# **A1 in Northumberland: Morpeth to Ellingham**

**Scheme Number: TR010059**

## **Applicant's Response to Relevant Representations**

<b>Regulation Reference:</b>	APFP Regulation Rule 8(1)(c)
<b>Planning Inspectorate Scheme Reference</b>	TR010059
<b>Application Document Reference</b>	TR010059/6.7
<b>Author:</b>	A1 in Northumberland: Morpeth to Ellingham Project Team, Highways England

highways  
england

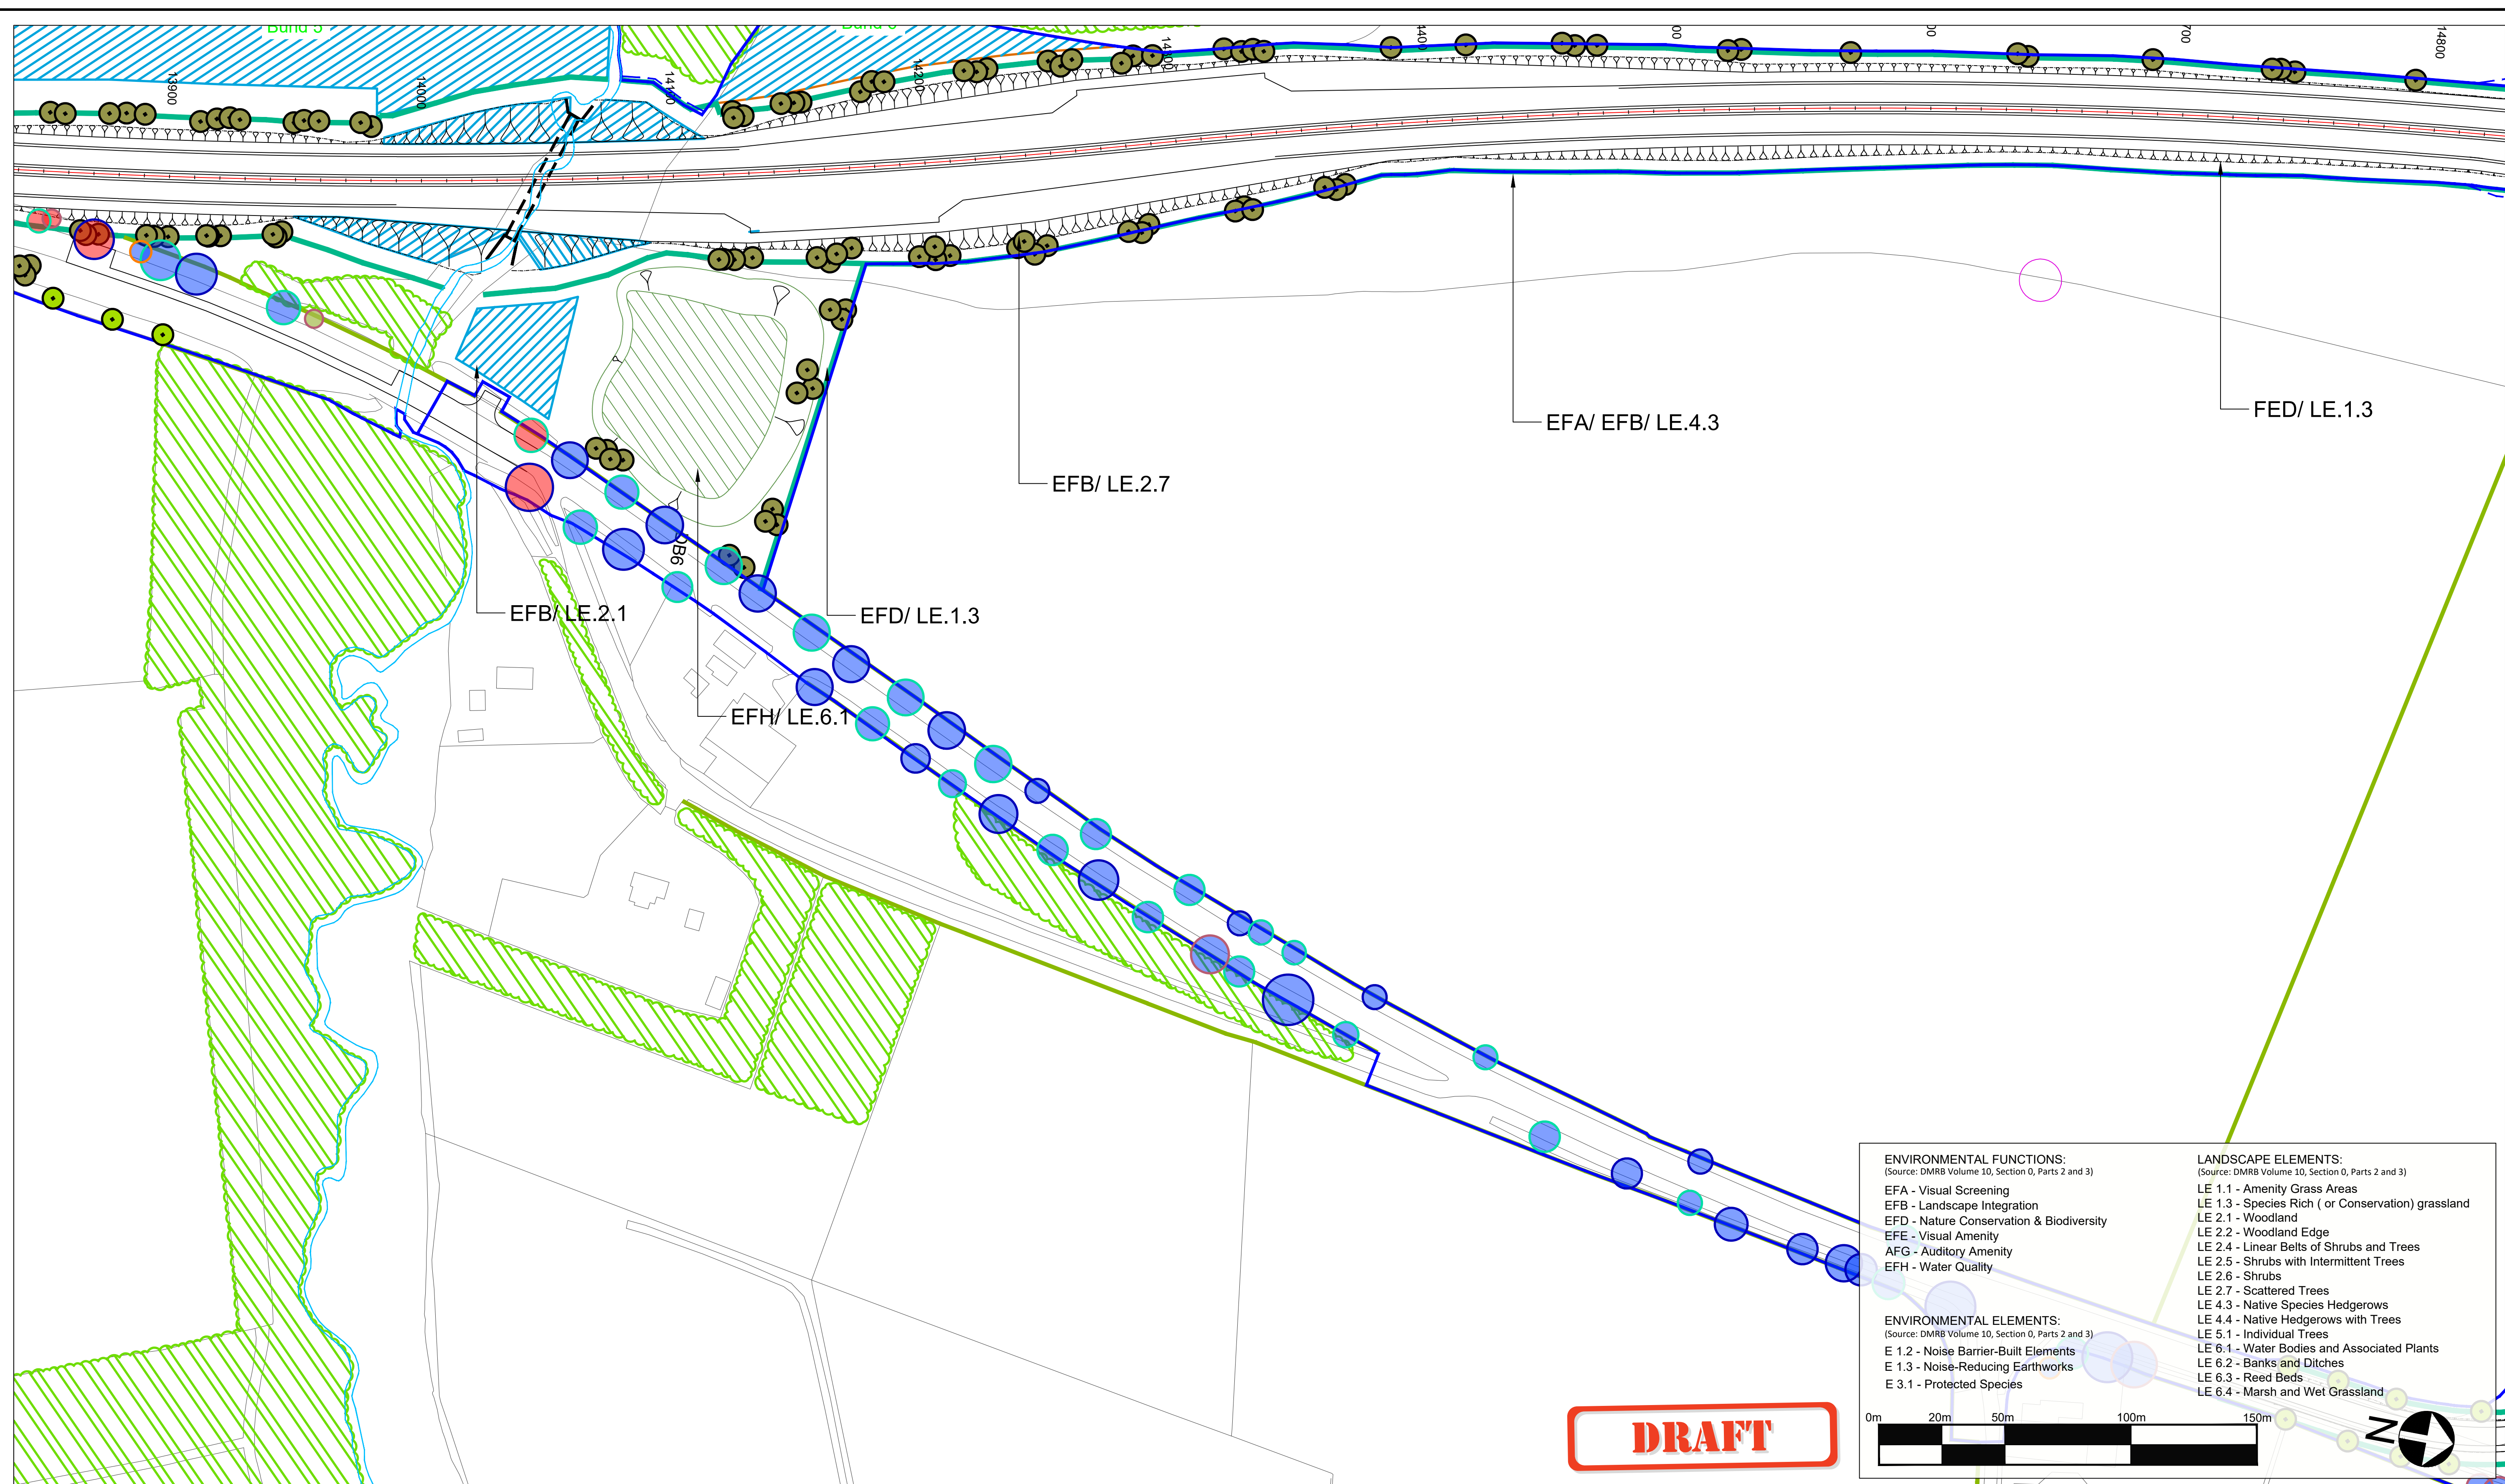
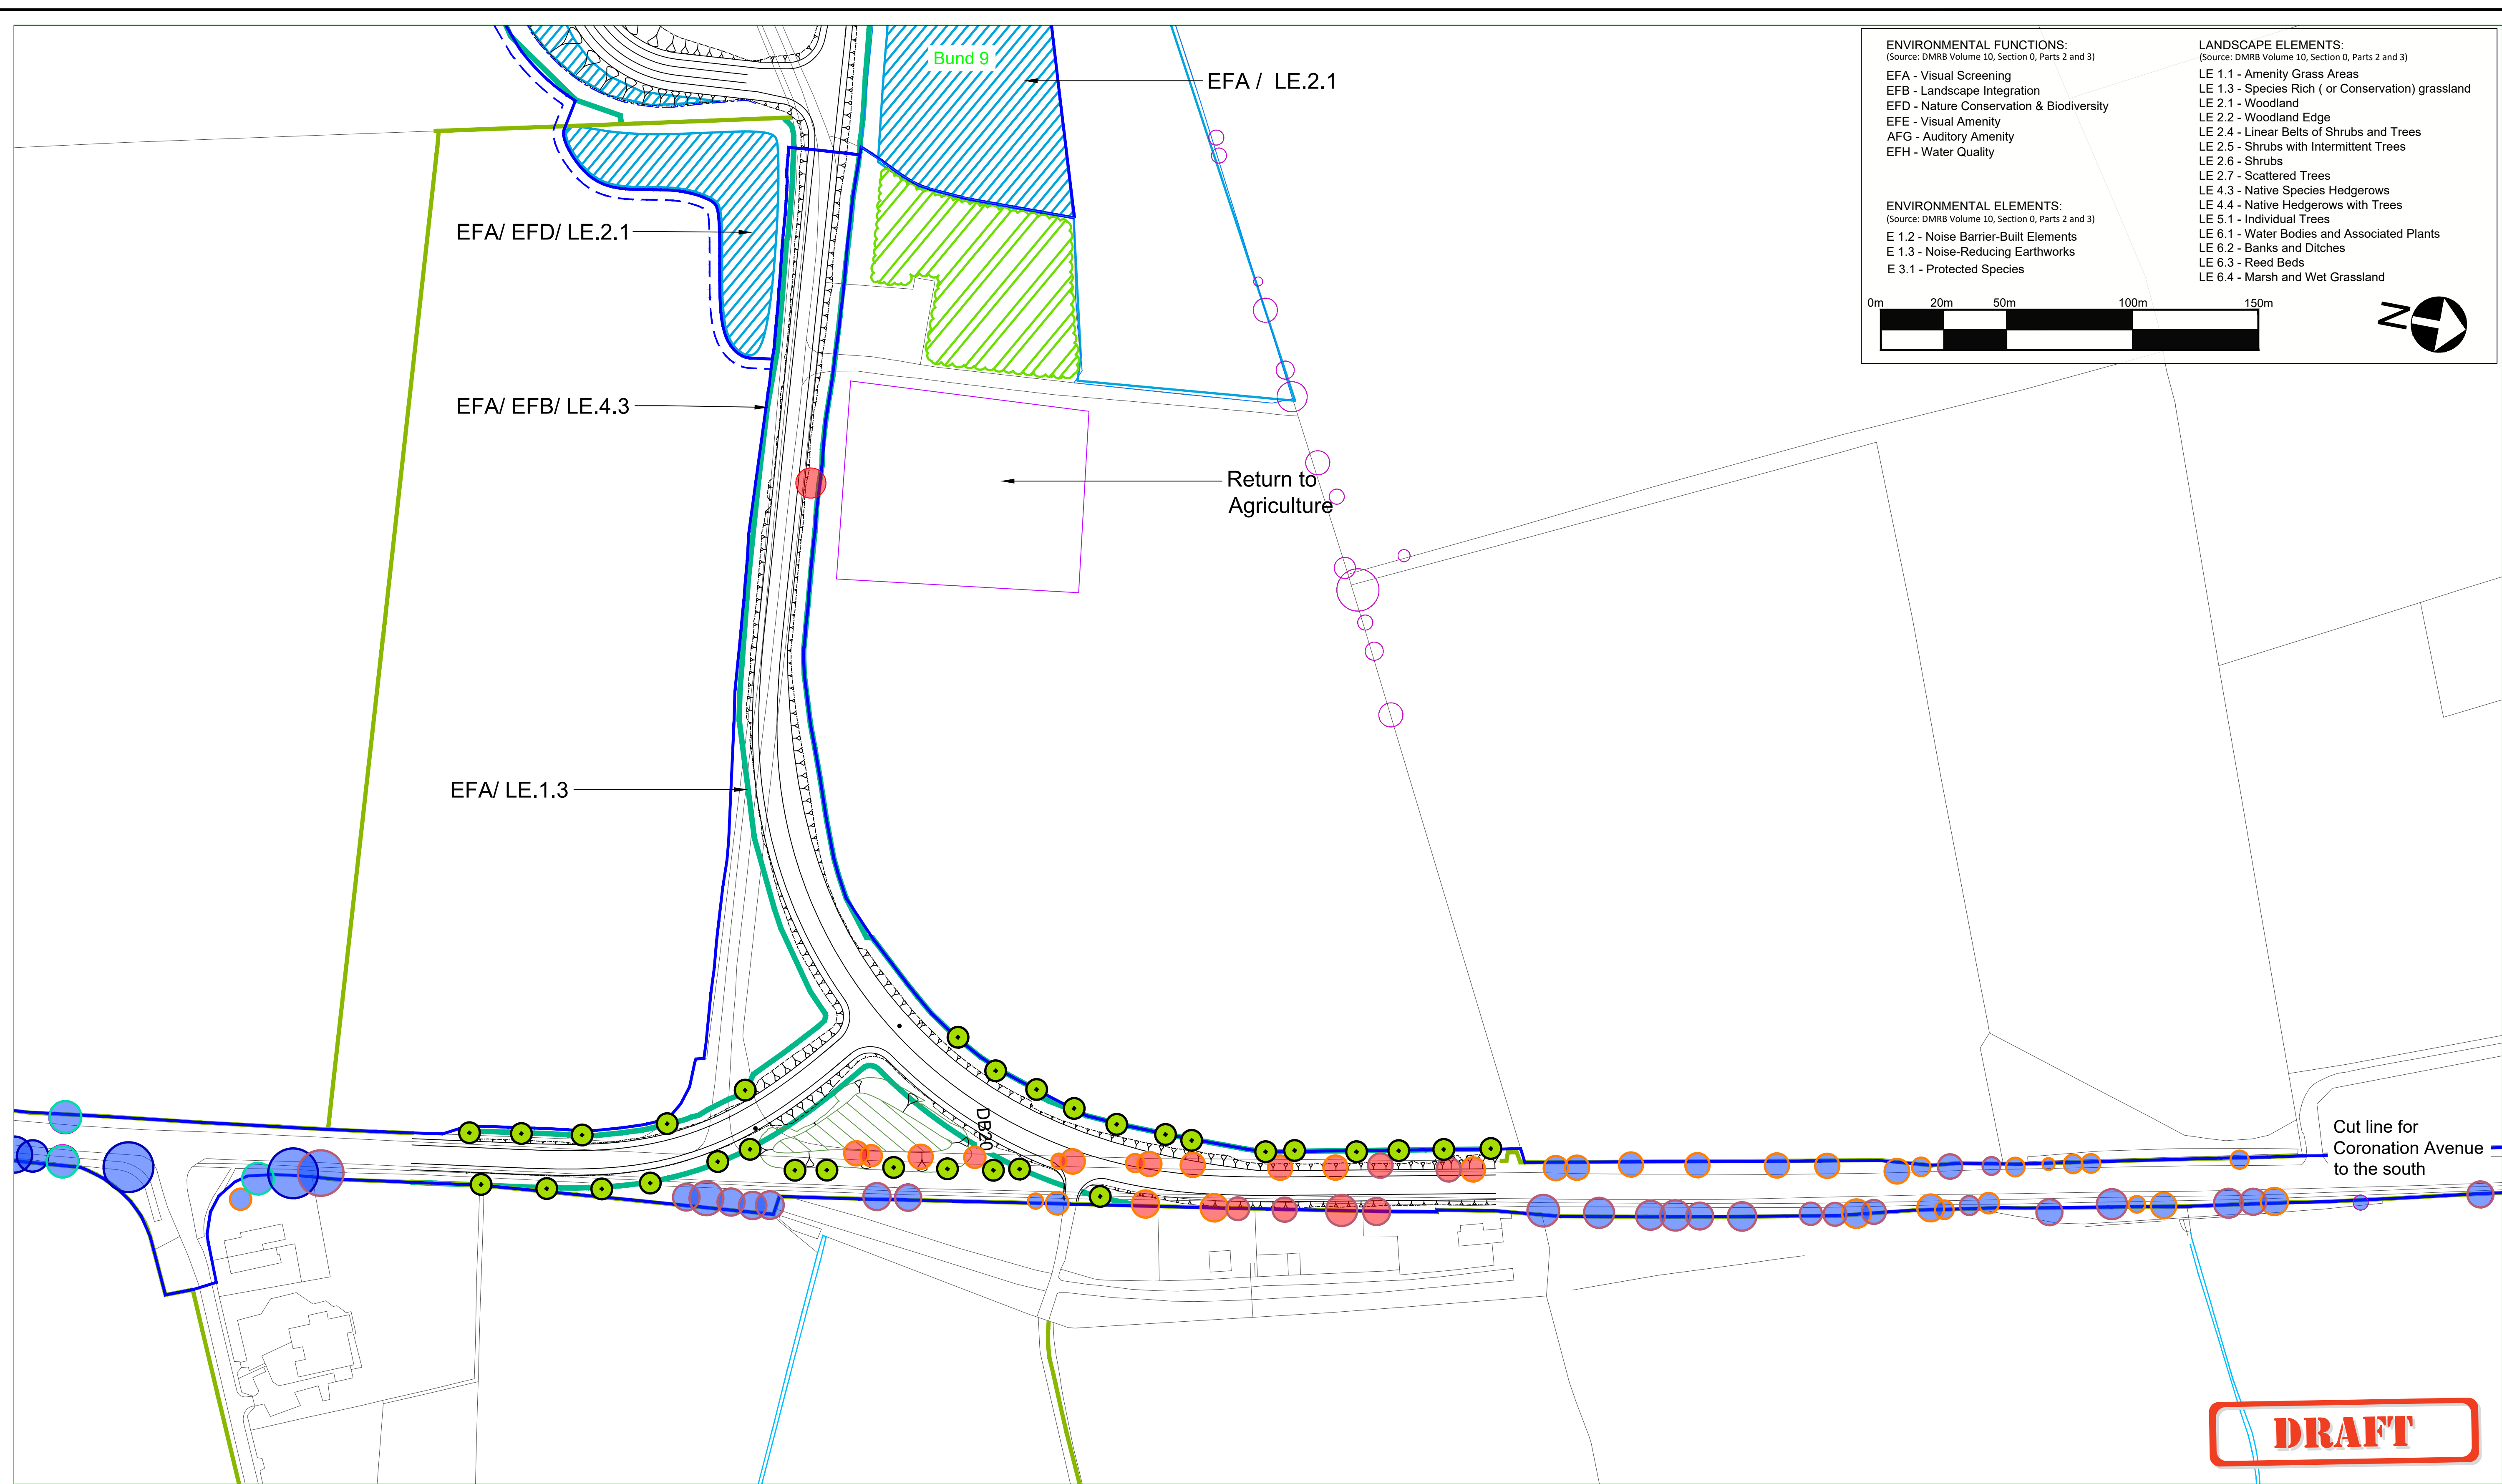
1.1.23	<p>The replacement Coronation Avenue is a token gesture, consisting of trees spaced roughly every 100m. This avenue plays an important role in retaining a rural, well vegetated character through this section of the route and the LVIA is quite clear about the local importance of the Avenue as a landscape feature and the sparse nature of the replacement compared to what is removed is not explained or justified in the application.</p>	<ol style="list-style-type: none"> <li>1. In paragraph 7.8.10 of Chapter 7: Landscape and Visual, Part A [APP-044] it is acknowledged that 187 no. of the 300 no. trees that form the Coronation Avenue would be removed by the Scheme. Figure 7.8: Landscape Mitigation Masterplan Part A, [APP-095] identifies the indicative location of the replacement trees, at regular intervals along the extent of the A1 where the presence of trees planted as part of the Coronation Avenue currently exist, totalling 38no. As has been identified above, the Landscape design as set out in Figure 7.8: Landscape Mitigation Masterplan Part A, [APP-095] including any replacement vegetation and trees to restore the Coronation Avenue will be approved by the Secretary of State following consultation with NCC as per Requirement 5, Schedule 2 of the draft DCO [APP-014]. The Applicant has prepared a draft strategy for the replacement of trees along the Coronation Avenue, identifying the final number and spacings of the replacement trees that would be planted to restore the landscape feature, refer to Appendix LV.2 submitted at Deadline 1 in response</li> </ol>

Reference	Comment from Relevant Representation	Applicant's Response
		to ExA Written Question LV.1.8, having been discussed and agreed with NCC via email January 2021.
